# **Proposed Extension of Chatswood Chase Shopping Centre**

## **Response to Traffic Matters Raised in Willoughby Council's Letter of 12 August**

MALVERN AVENUE CARPARK ENTRY

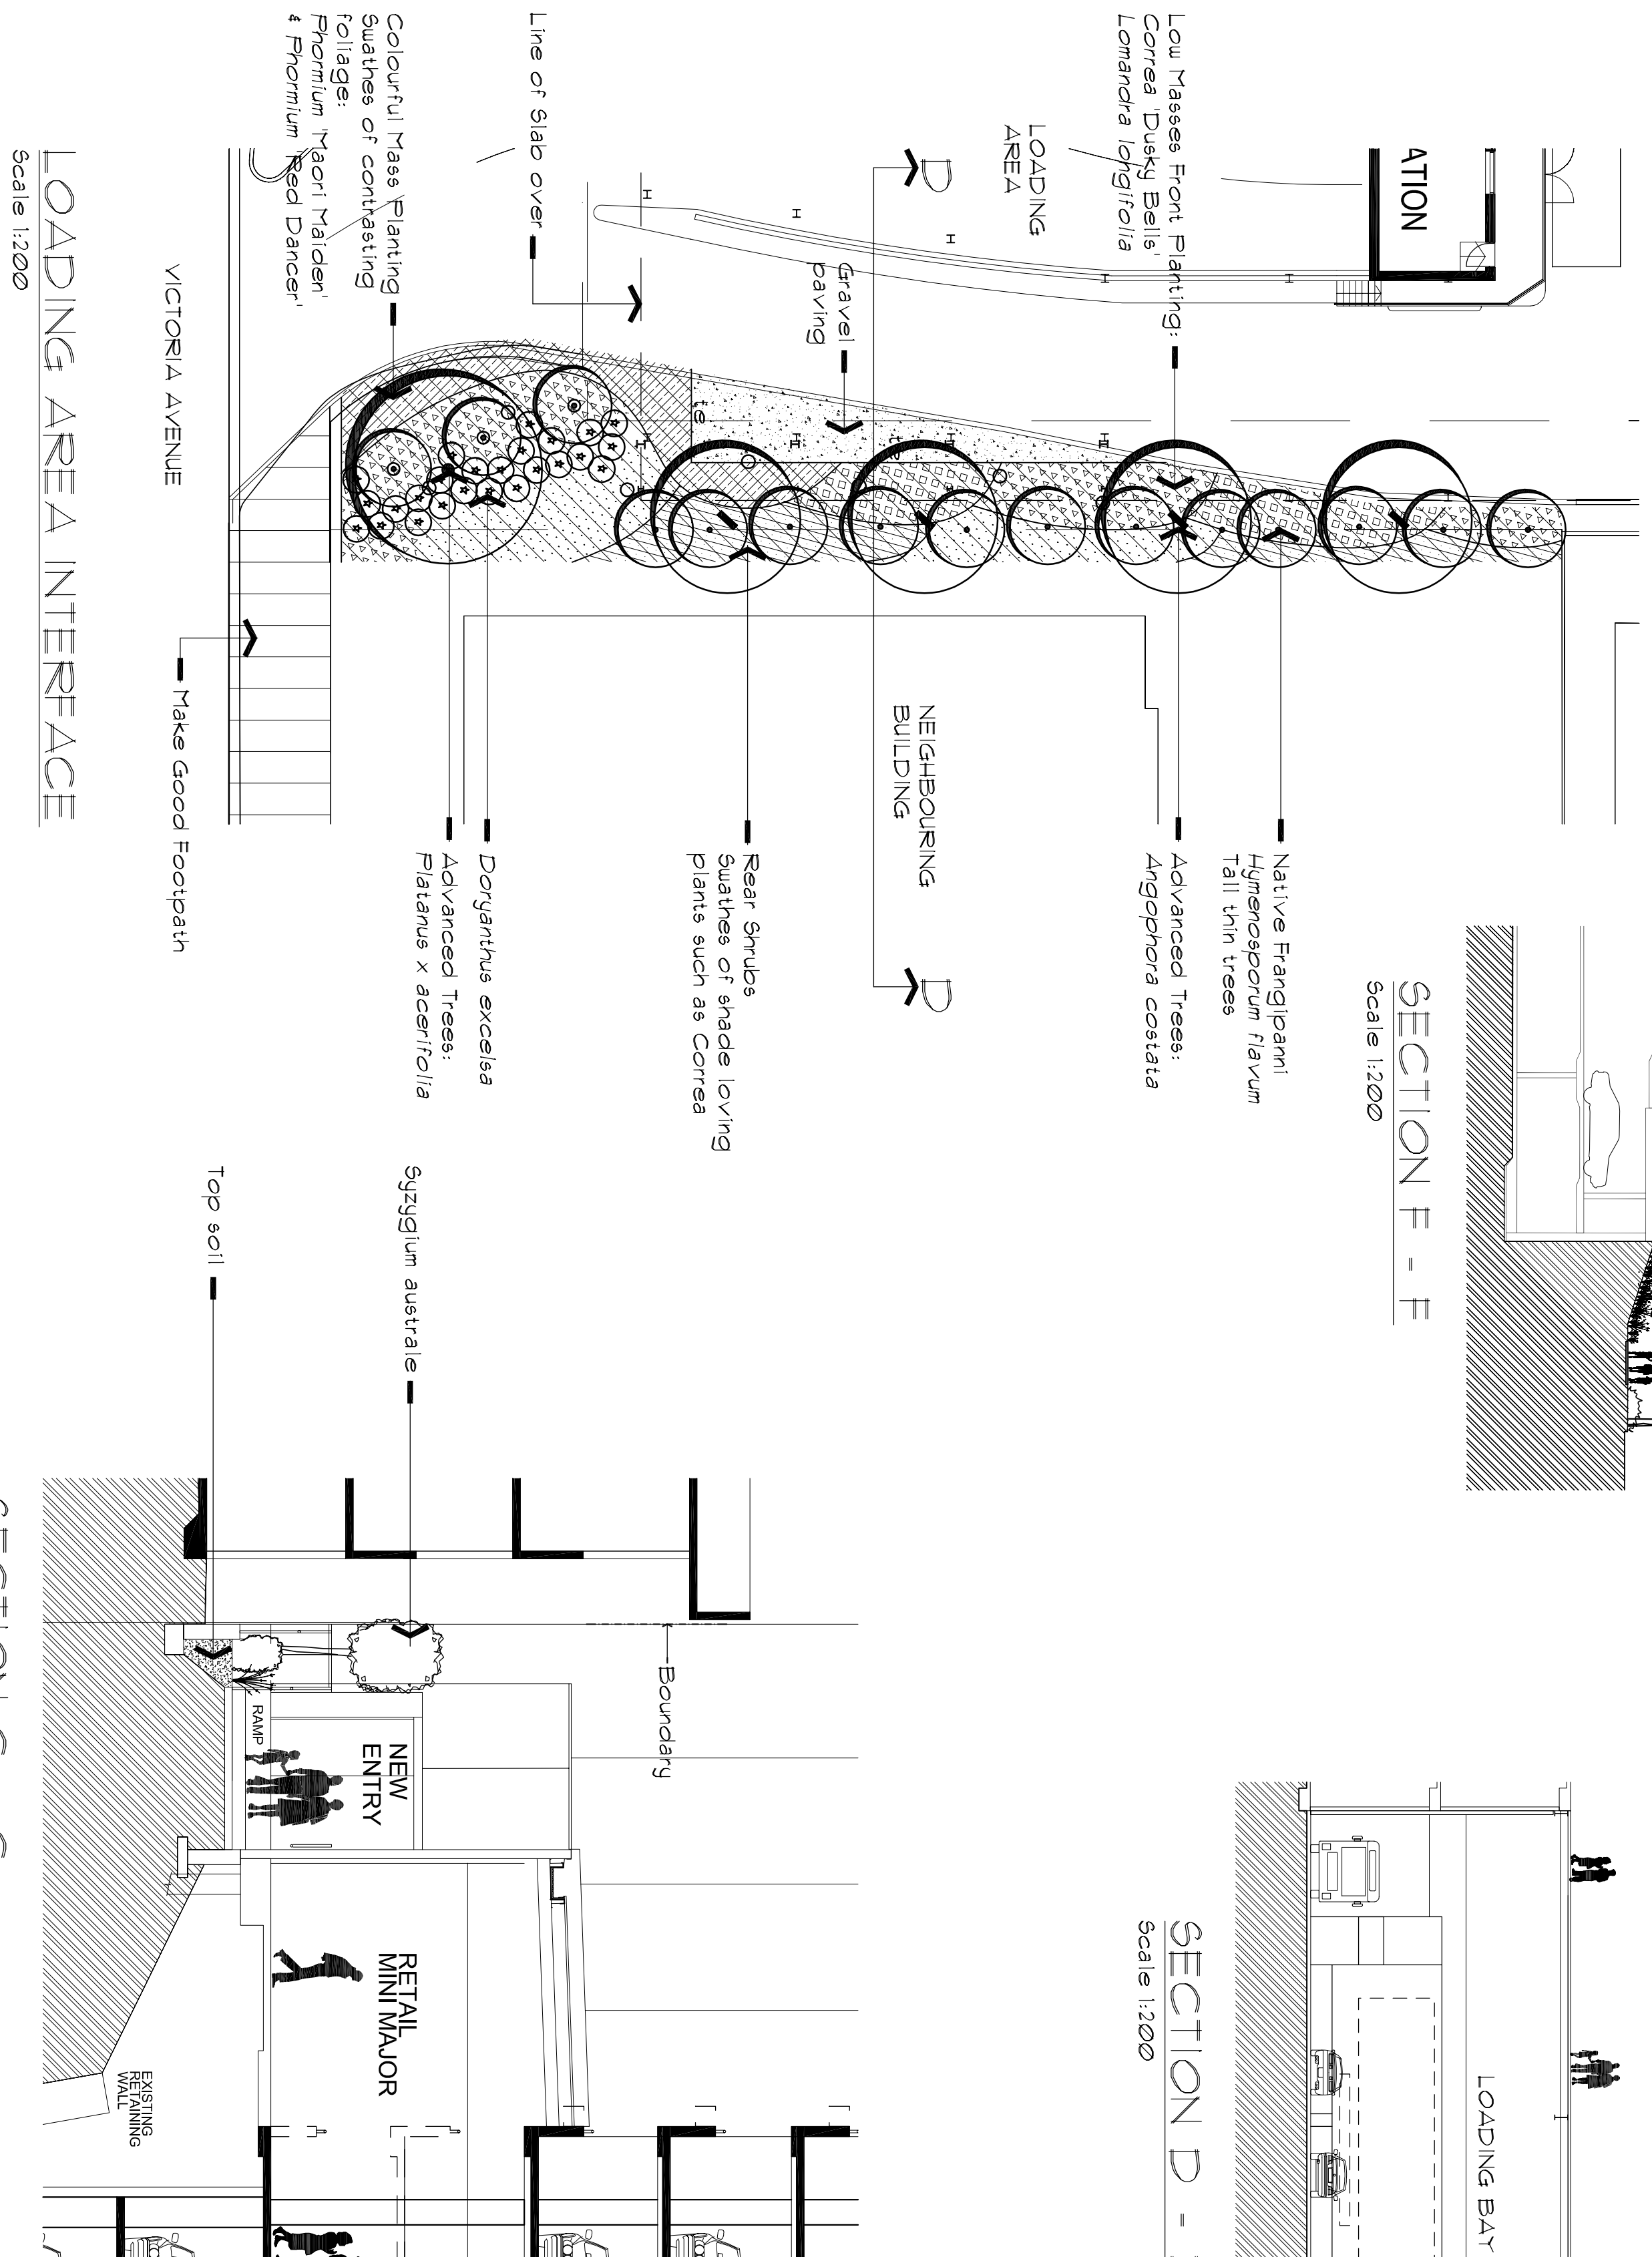
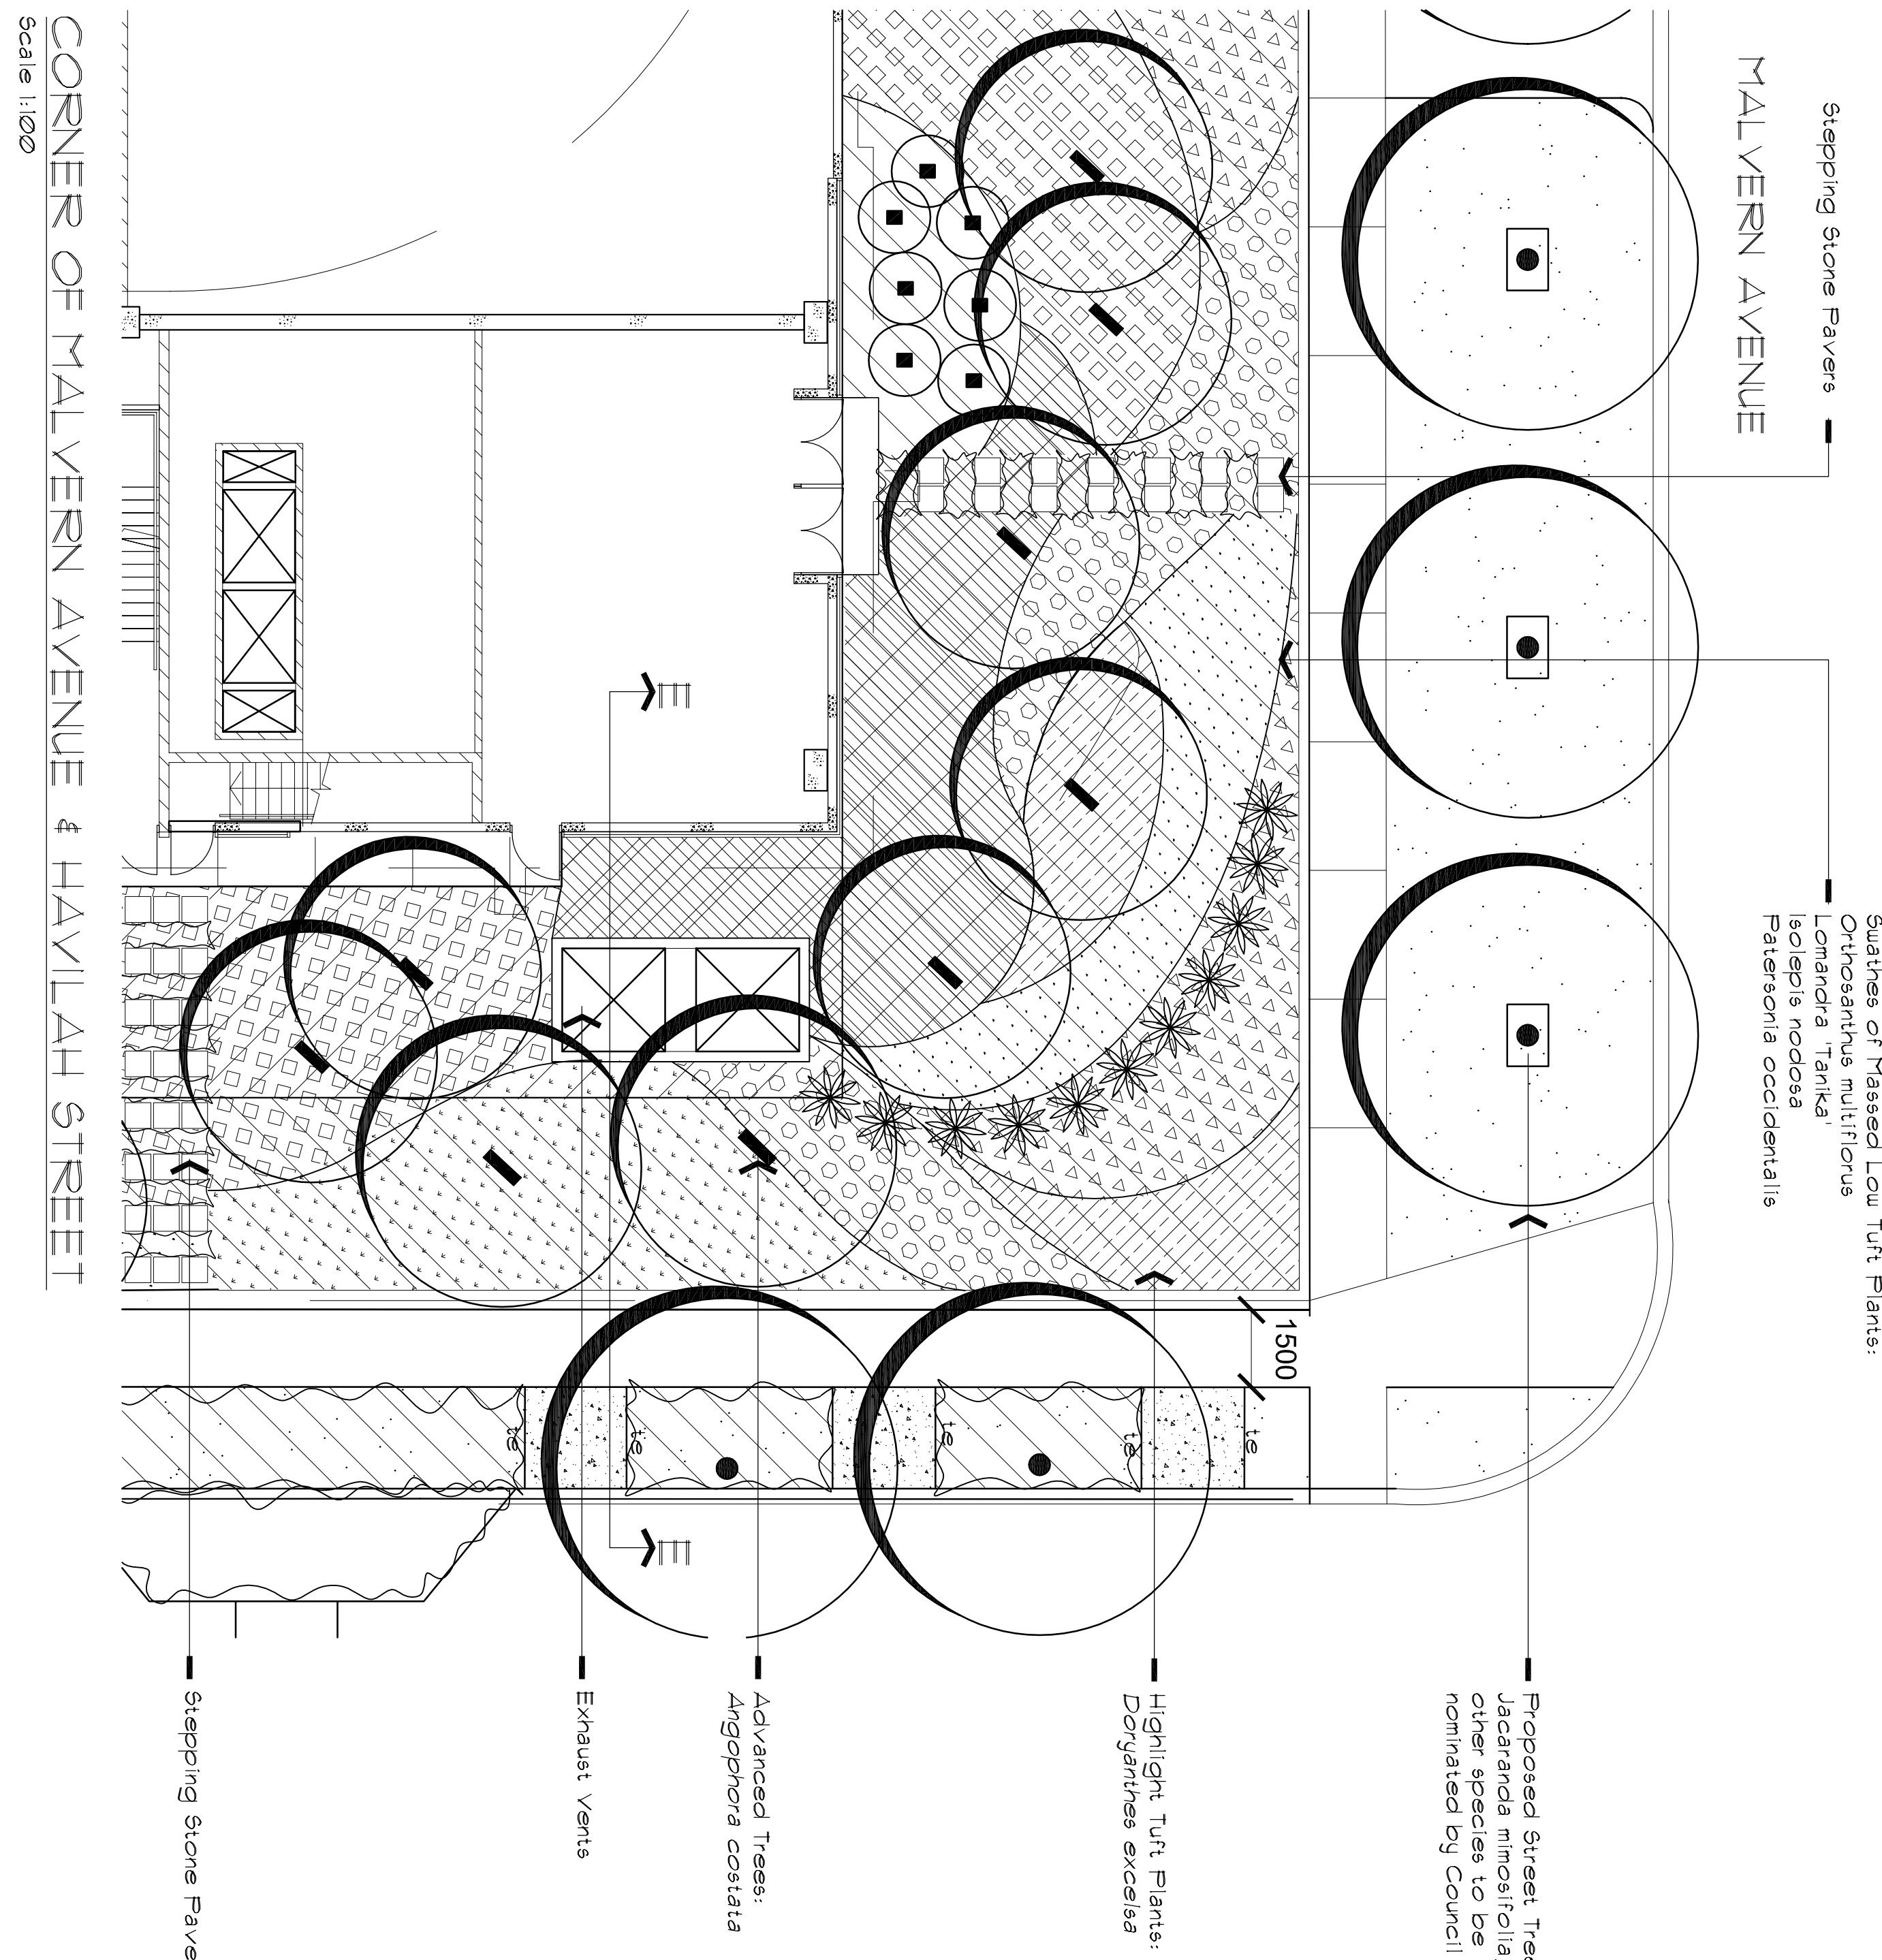
**Item m) Redesign of Malvern Avenue driveways**

The design has been modified to separate the driveways as suggested by Council. The potential for improved delineation of movements in Malvern Avenue is being investigated in conjunction with landscaping plans.
